Development Control
Ribble Valley Borough Council

App no: 21.1134

Address: Land east of Chipping Lane, Longridge

Proposal: Development of 47 no. homes including affordable housing and housing for the elderly

2010 Range - Garage Drawing		Single Detached Garage - Classic Stone	
Date	Feb 2013	2010/DET/CS/01	Scale
Drawn by	SAH		
Checked by			
Revision		1:50 / 1:100 @ A3

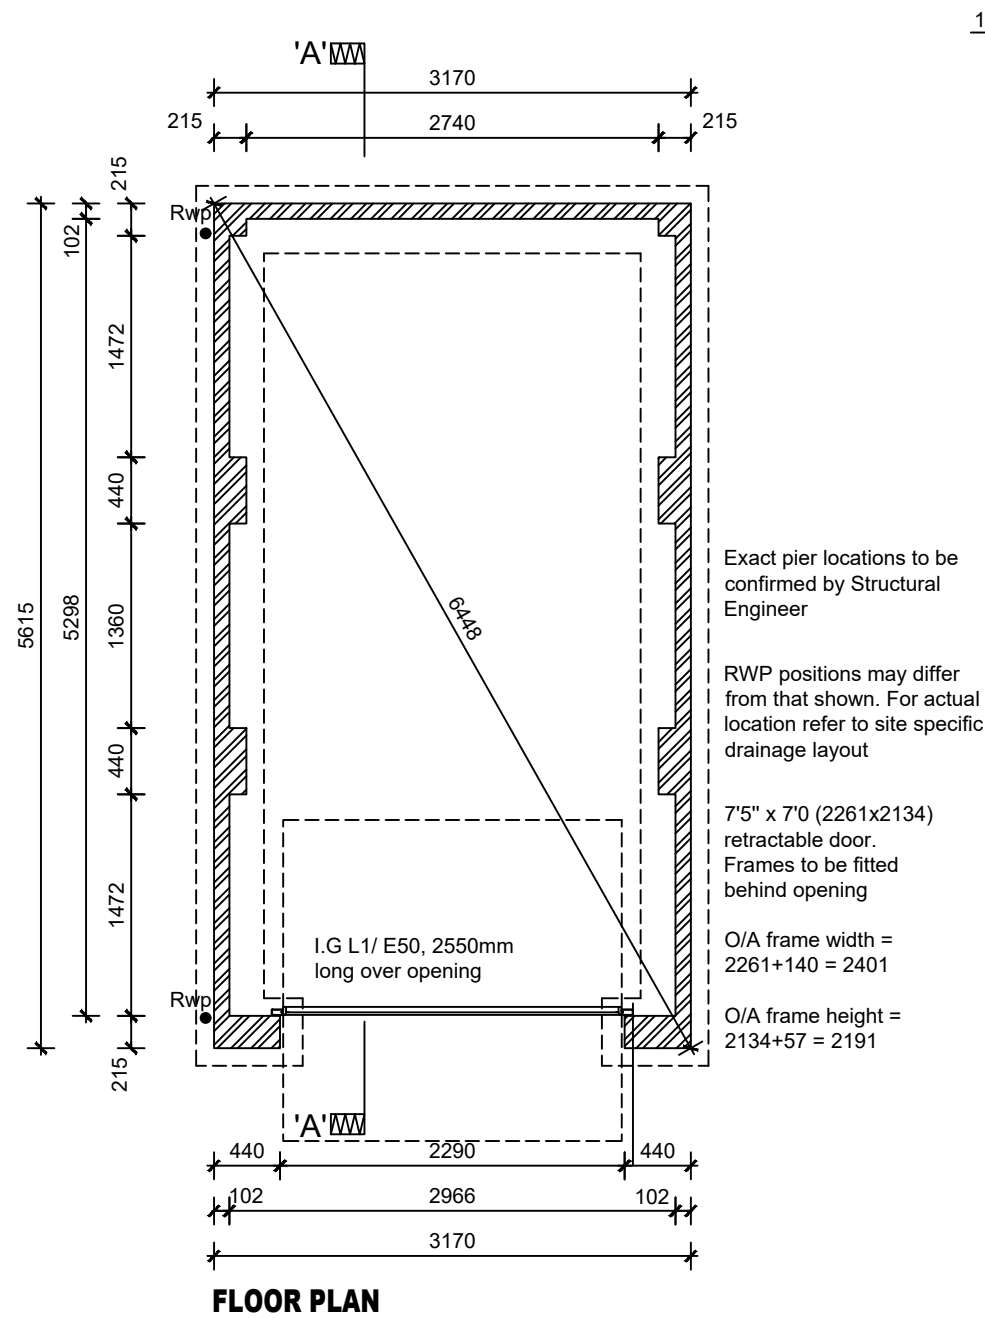
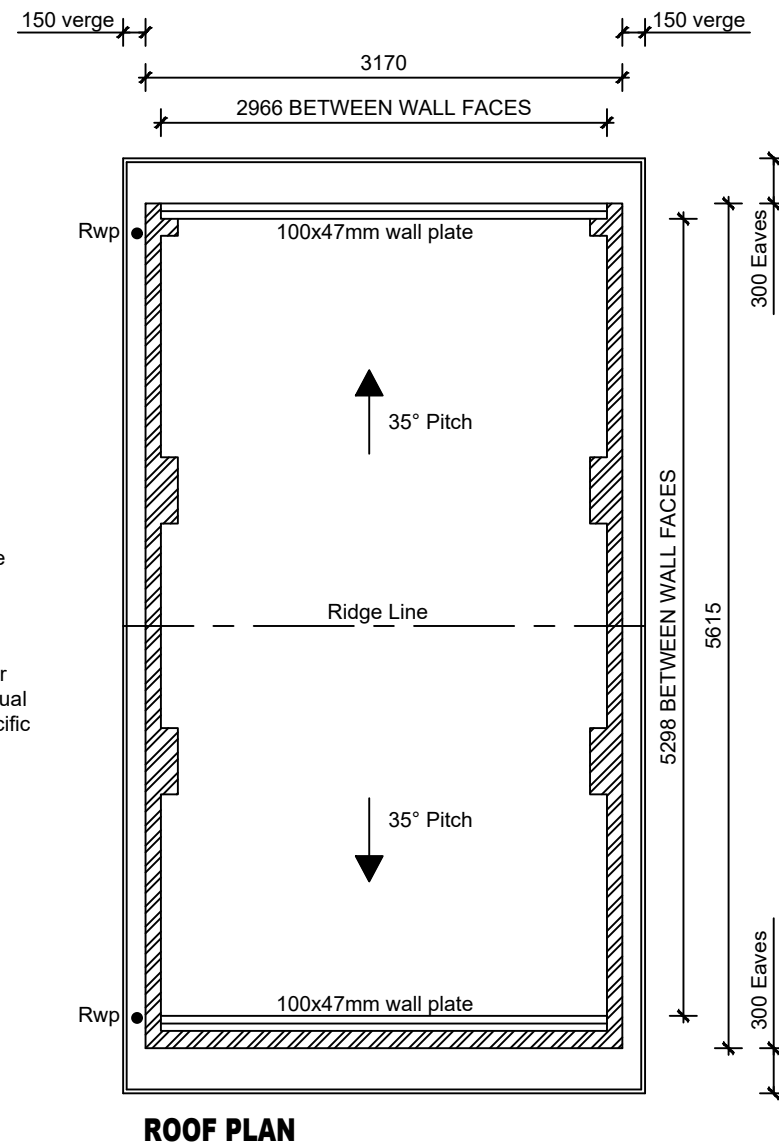
The proposed garages are below the recommended size of 3m x 6m to count as a parking space, the Denby and Winfield are 5m x 2.6m and 4.9m x 2.4m respectively and the detached garages are 5.298m by 2.74m. They can be counted as secure, cycle parking.
